Our Ref: LU/299/20/NMA

Non Material amendment following grant of reference LU/305/19/RES for substitution of landscape drawings.

Land South of Toddington Lane Littlehampton BN17 7PP

Persimmon Homes
North Littlehampton:
Parcel A2 & B6
LEAP Design **LA303**
Revision T

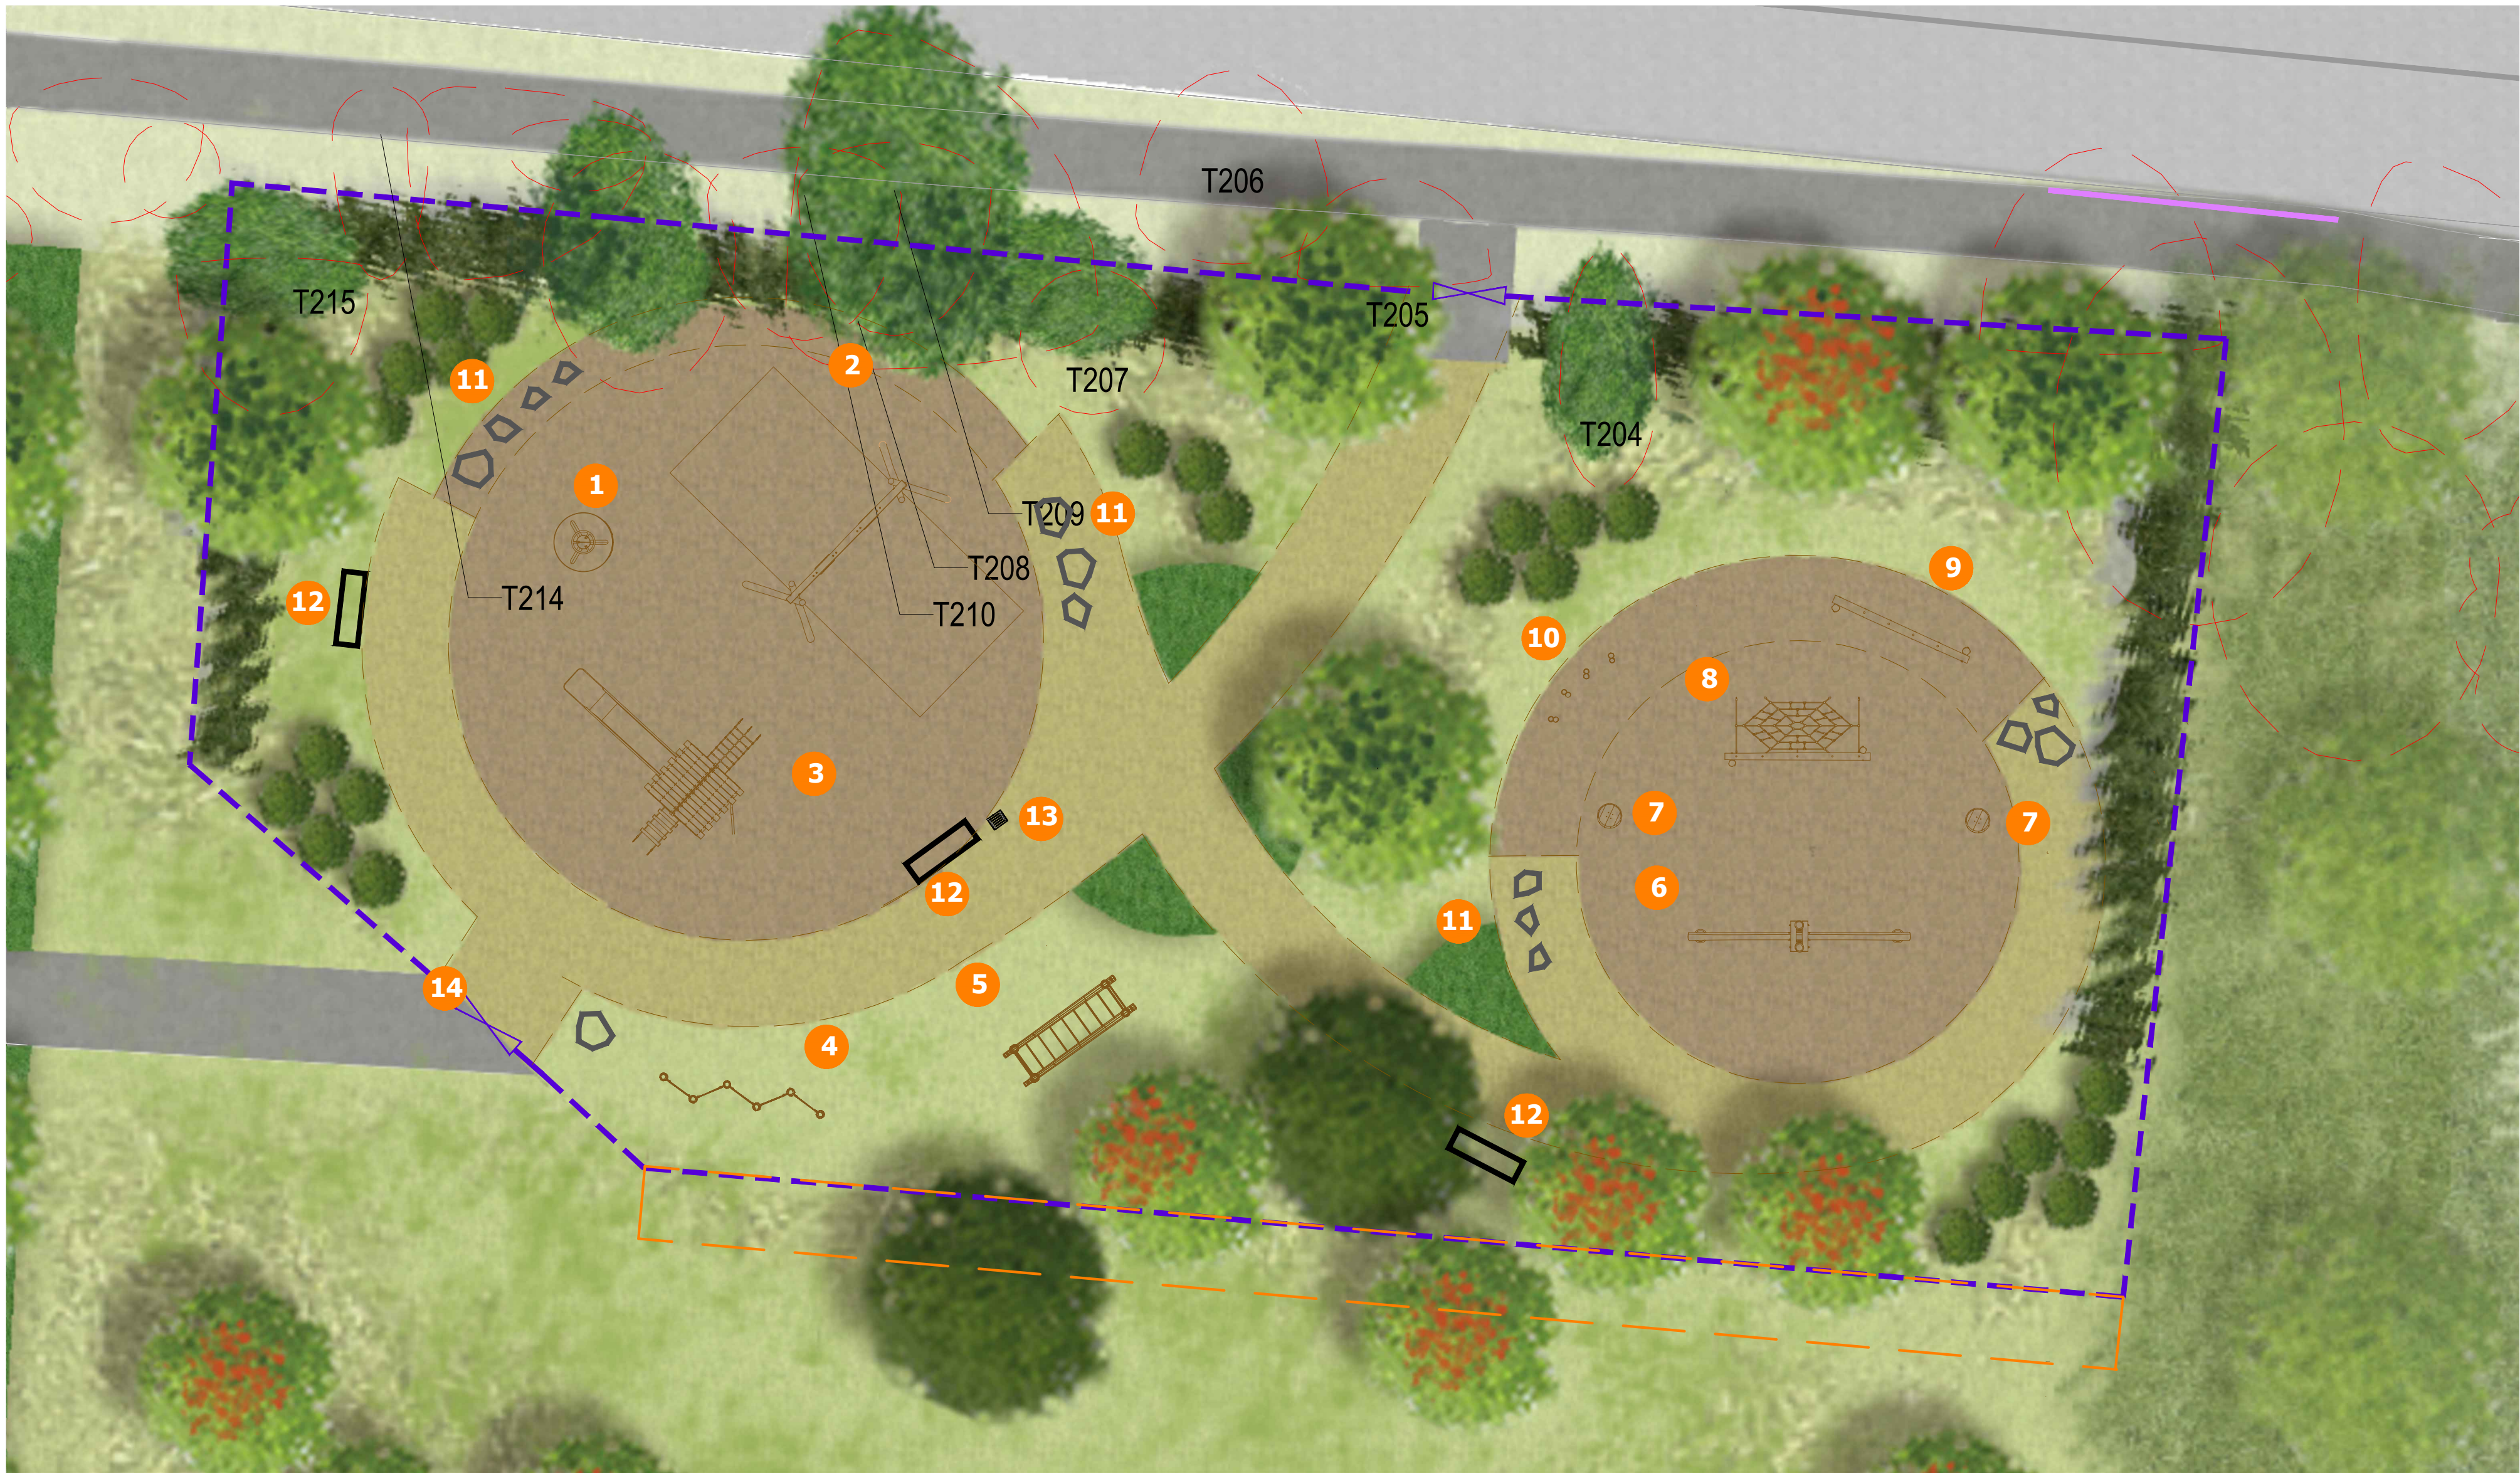
The difference between approved Revision S and proposed Revision T is that the a fence and gate enclosure around the Local Equipped Area of Play (the LEAP) was not shown on the Revision S drawing. Revision T includes the fence and gate enclosure around the LEAP.

Please note that Drawing No. RM3-300 Rev. T - Landscape Layout, Drawing No. RM3-301 Rev. T - Proposed Planting 1 of 2, Drawing No. RM3-302 Rev. T - Proposed Planting 2 of 2 and Drawing No. RM3-303 Rev. T - LEAP Design now form part of the approved planning documents and drawings for
